**KIRKLEES METROPOLITAN COUNCIL
INVESTMENT & REGENERATION SERVICE**

DELEGATED DECISION TO DETERMINE PLANNING APPLICATIONS

Reference No:	2021/62/91283/W
Site Address:	Waverley House, Waverley Street, Huddersfield, HD1 5NA
Description:	Installation of roof lights and formation of car parking (within a Conservation Area)
Recommending Officer:	Stuart Howden

DECISION – Refused

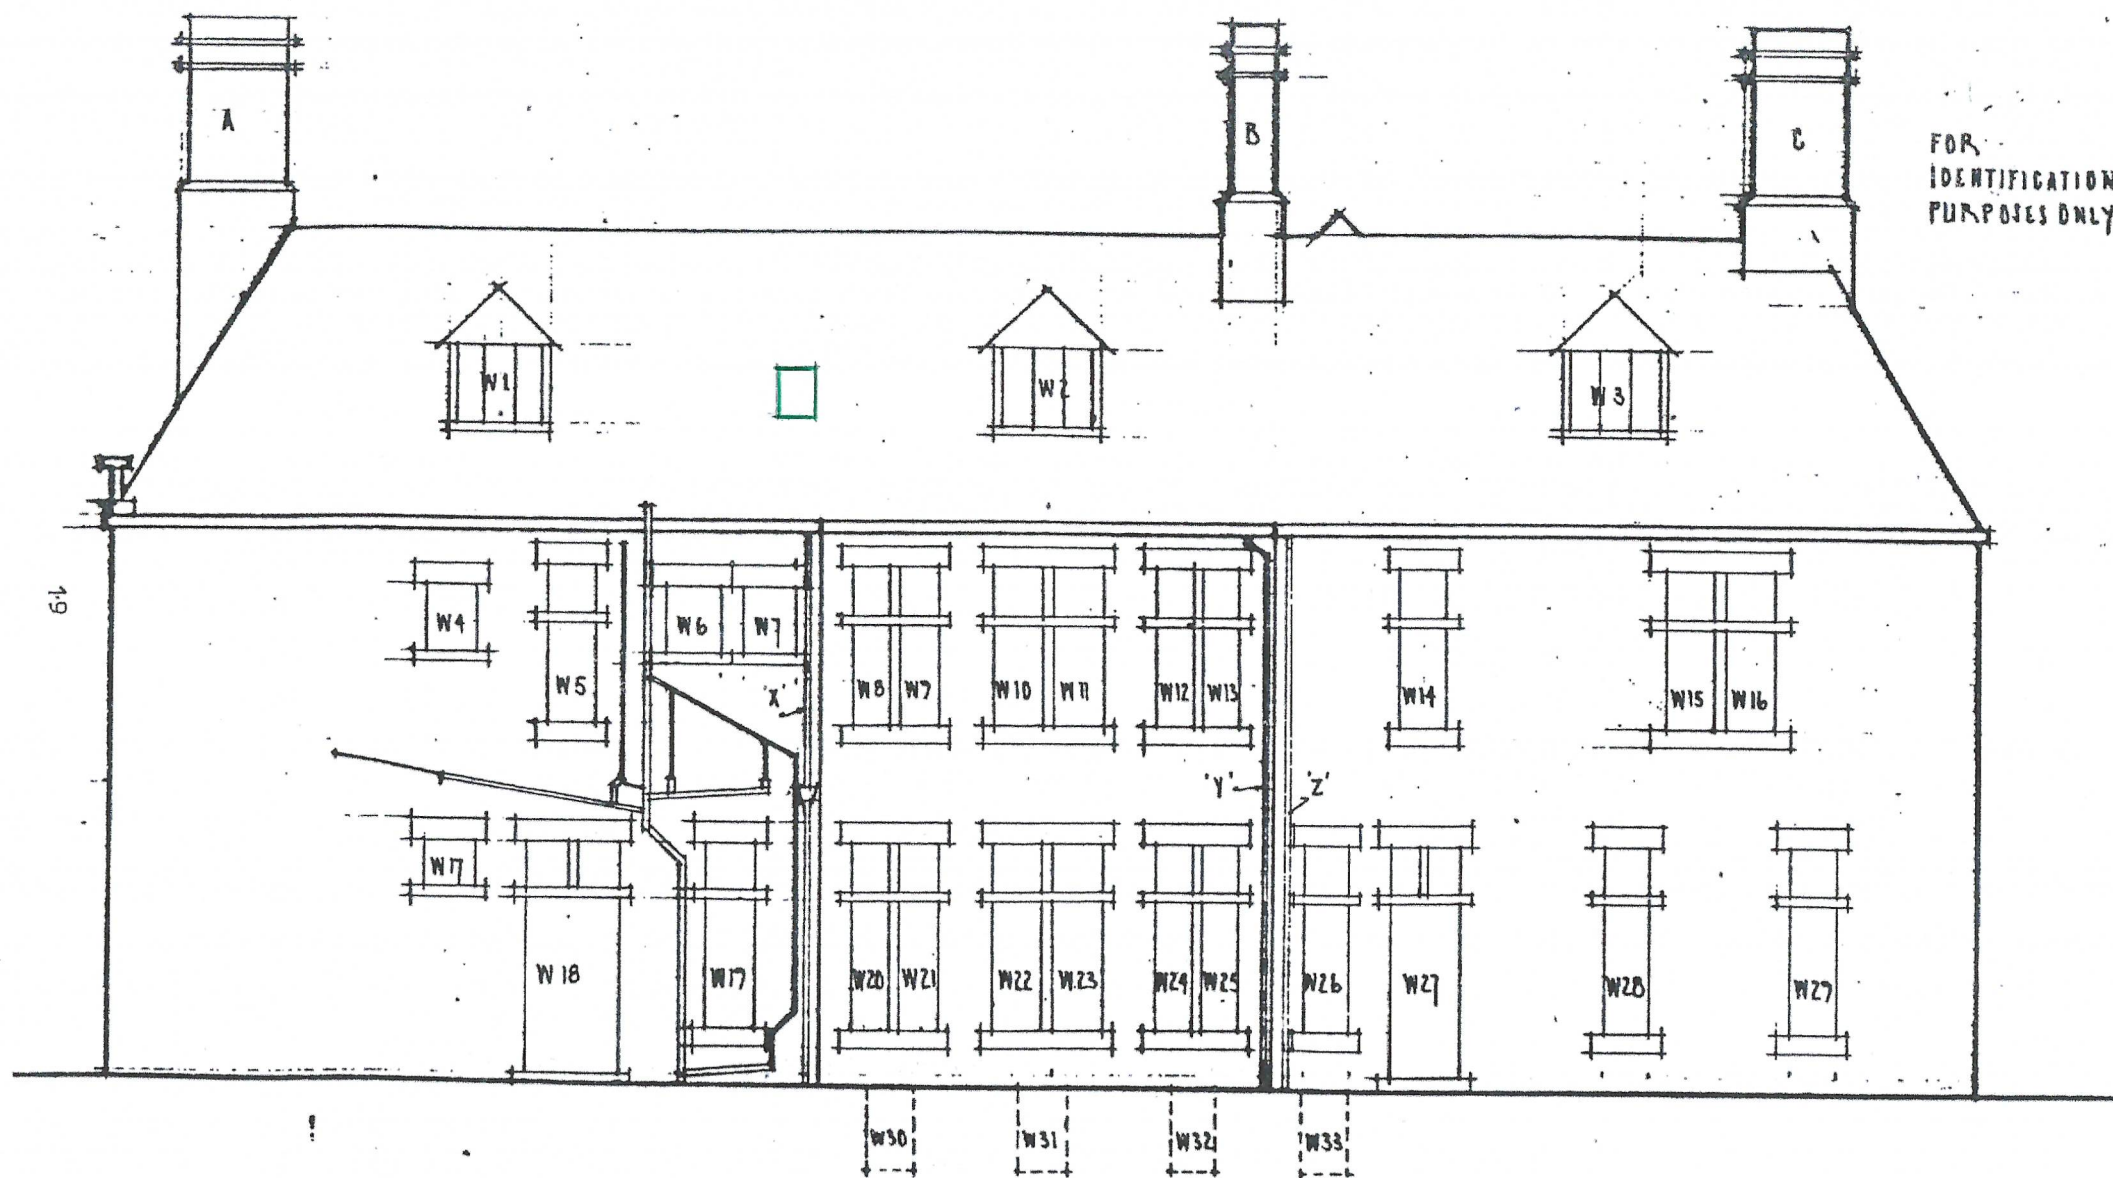
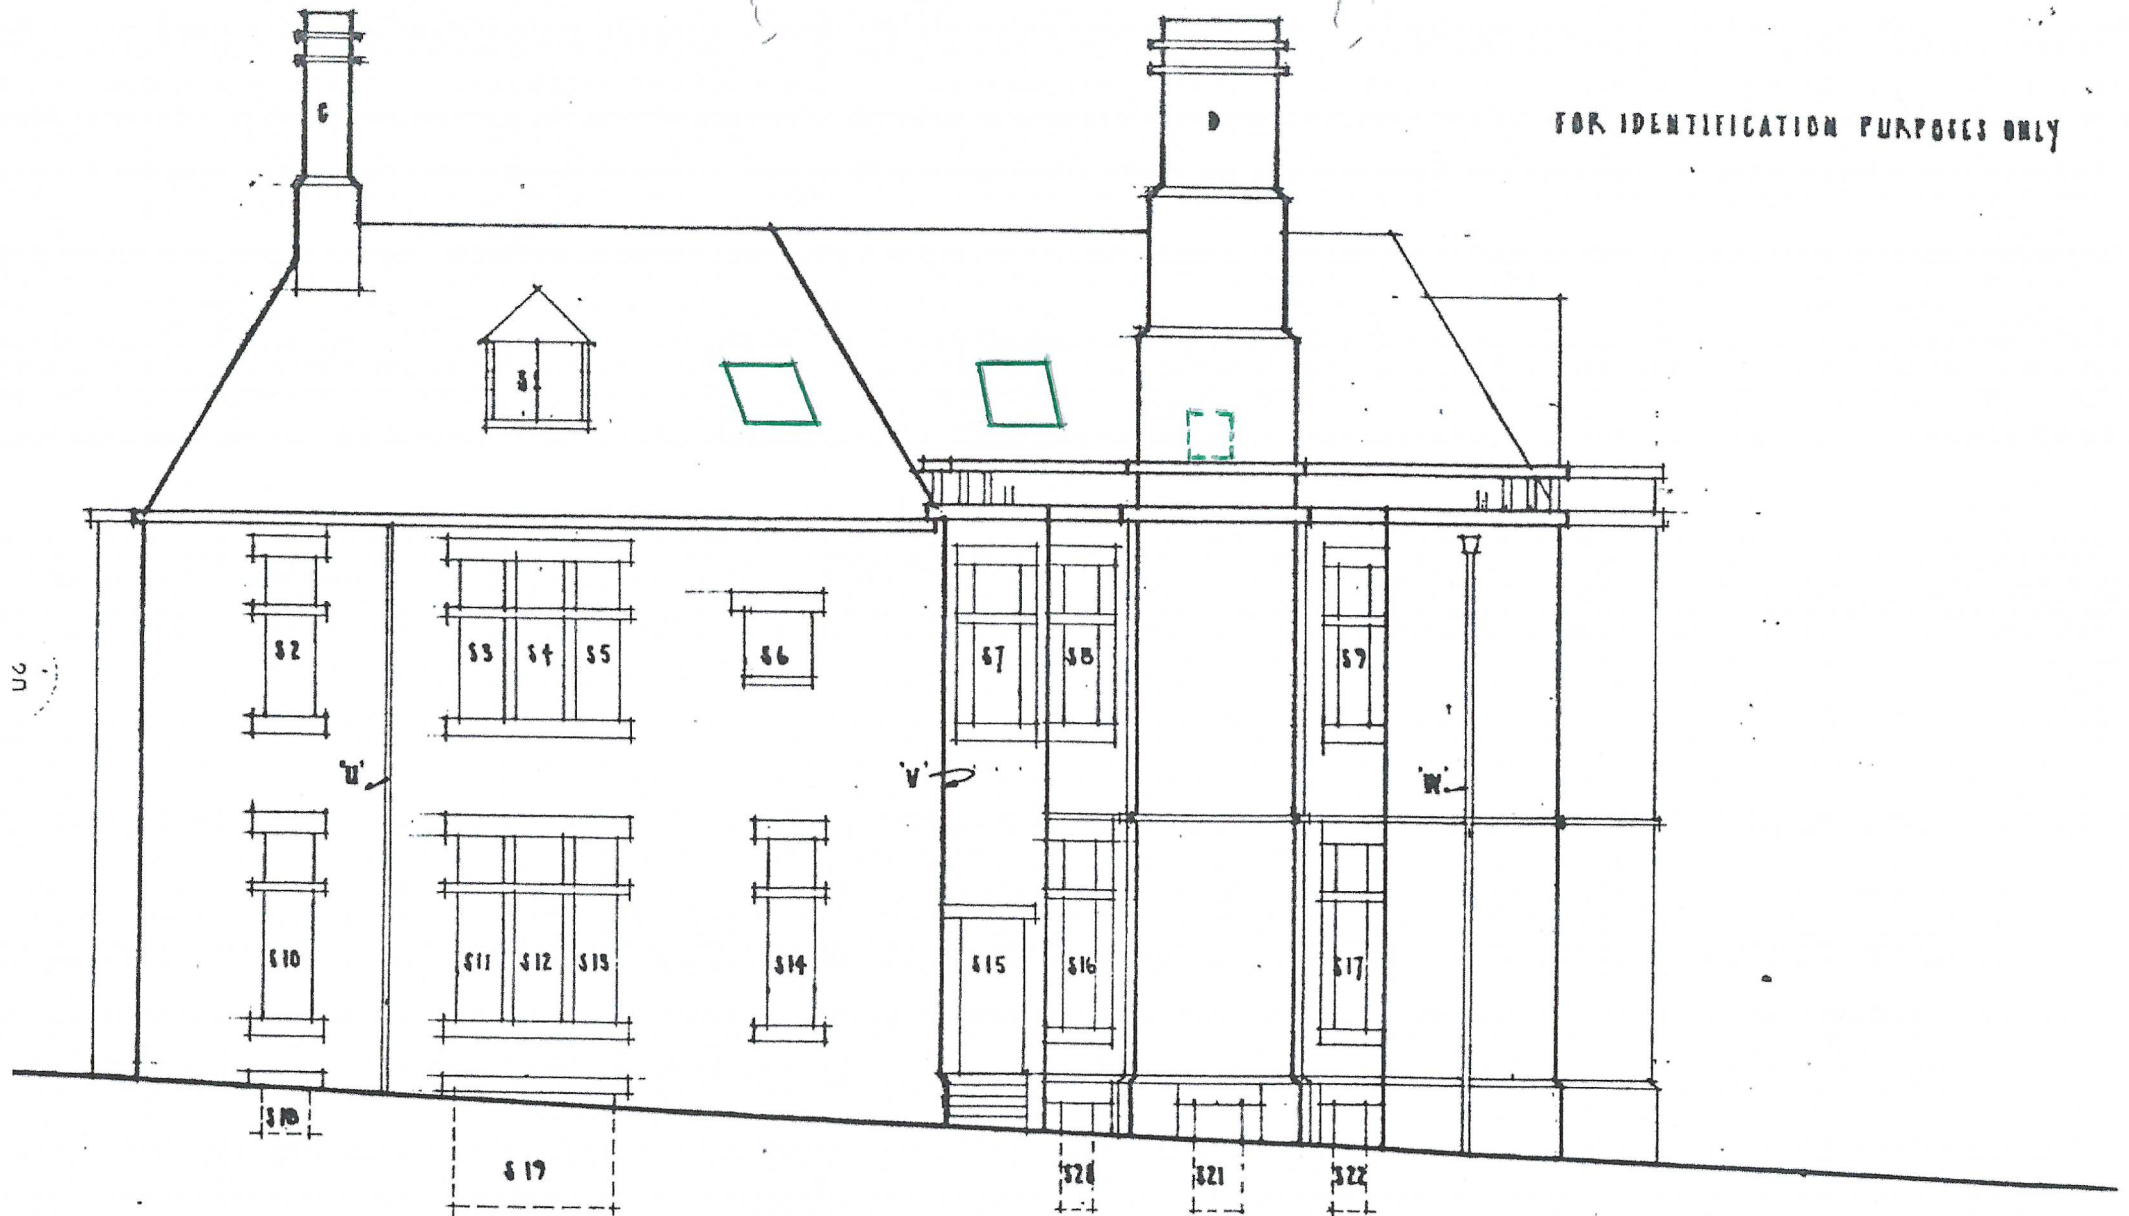
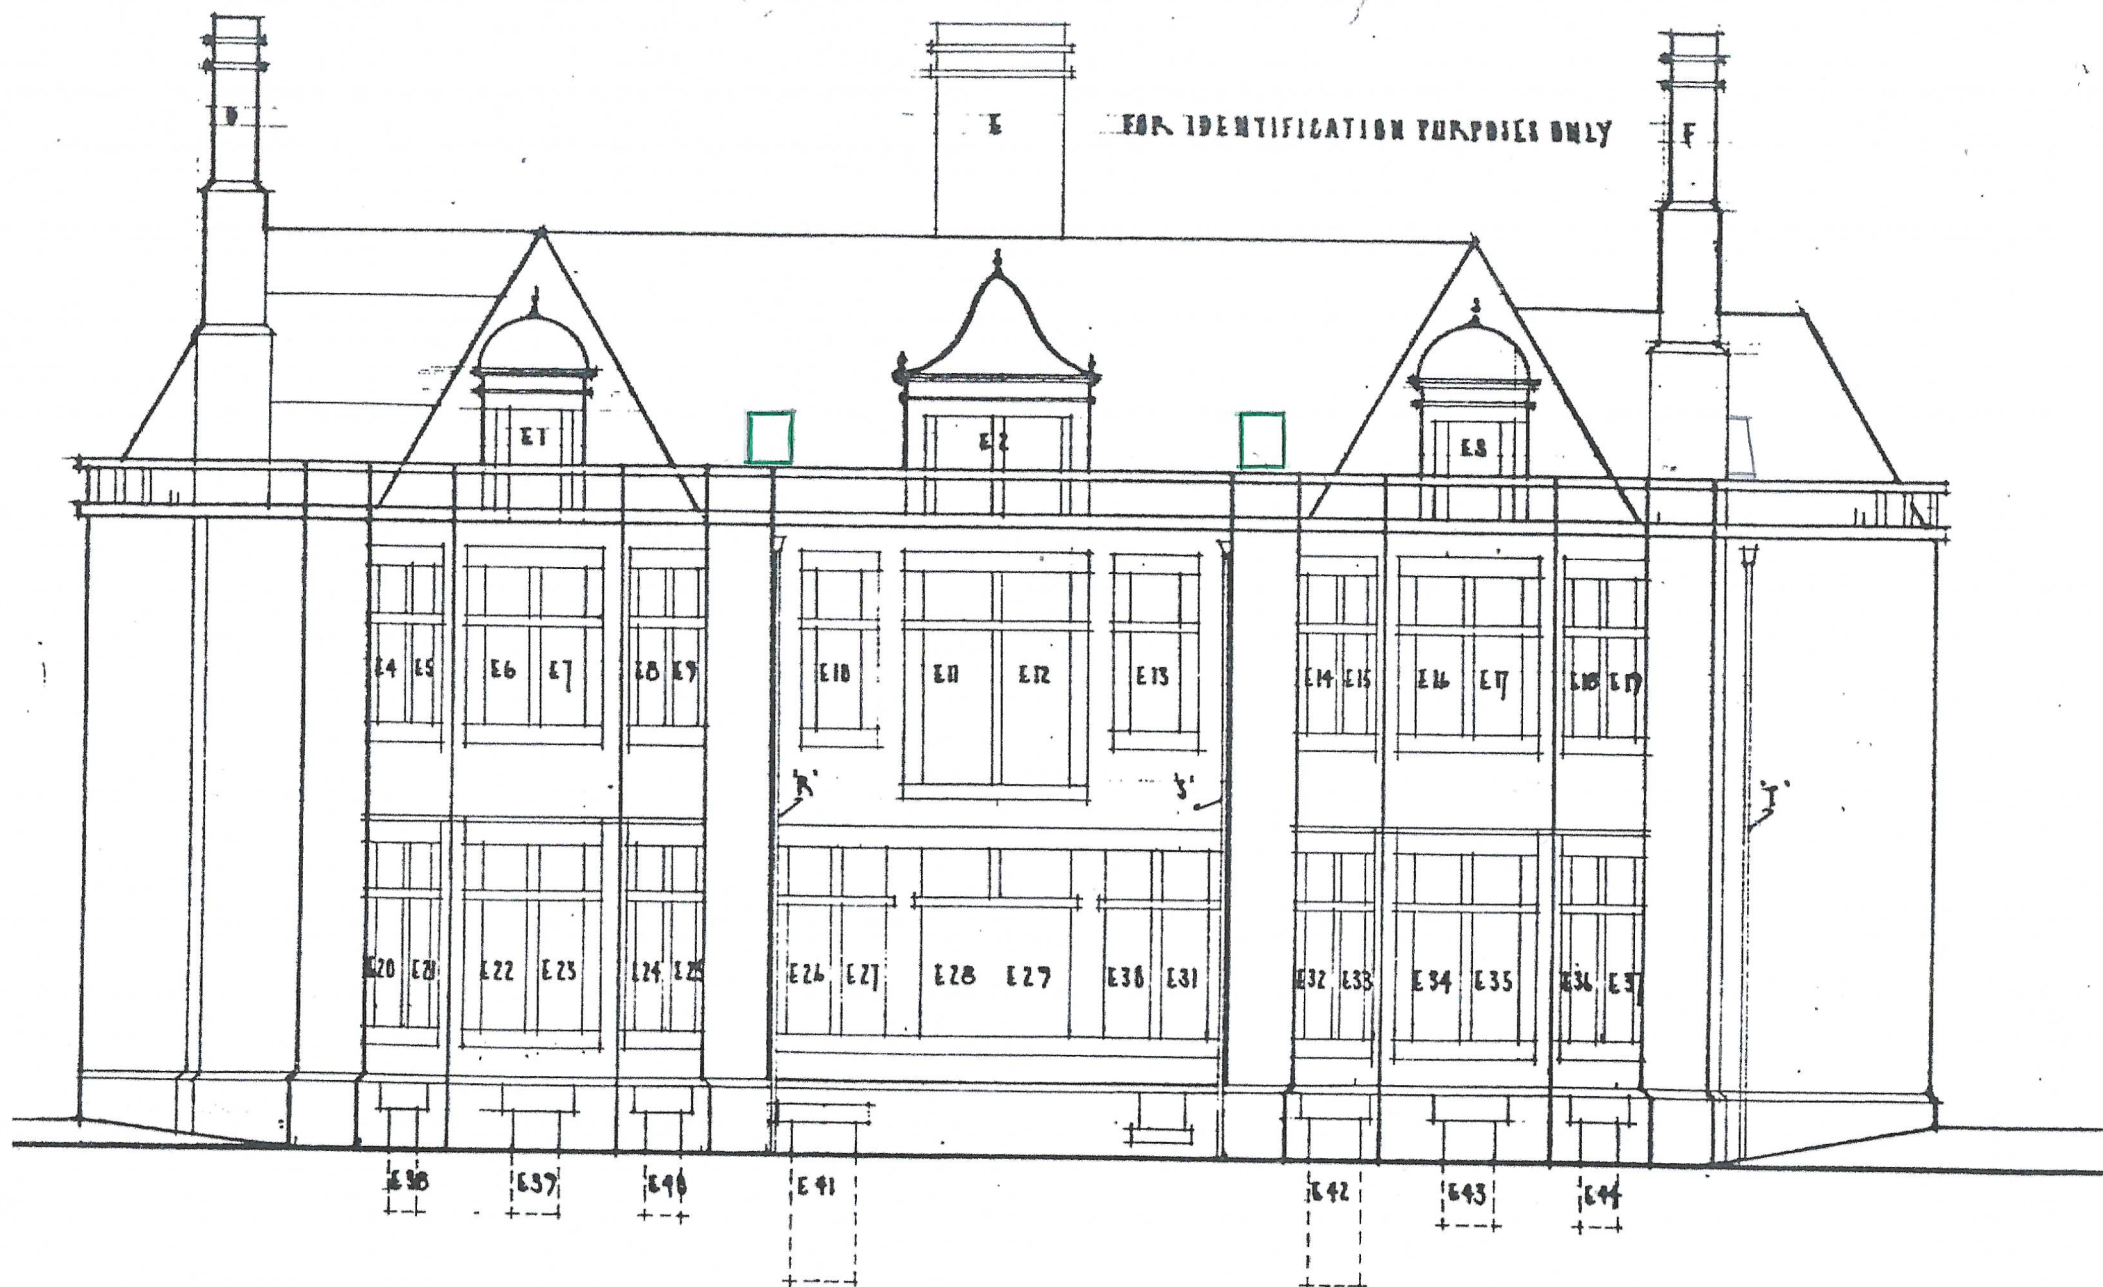
In relation to the proposed rooflights, the elevations display that 3 are proposed on the north elevation, 3 are proposed on the east elevation, 3 are proposed on the south elevation and 1 is proposed on the west elevation. However, the position of the rooflights on the elevations do not appear to be in a similar position to those on the floorplan drawing. That is, on the floor plan, 3 rooflights are displayed to be on the west roof slope whereas 1 rooflight is displayed to be on the east roof slope.

The Conservation Officer has stated that the alterations to the roofscape would have a harmful impact on the architectural character of the building and are required to accommodate a change of use of use which has yet to be authorised. The Conservation Officer has stated that the alterations to the roofscape should be clearly premised on the necessary and appropriate

The concerns of the Conservation Officer in relation to the rooflights are acknowledged. Of note, the position of some of the rooflights on the proposed elevations appears to be inconsistent with the position on the proposed second floor plan therefore it is difficult to fully ascertain what is proposed in respect of the rooflights here.
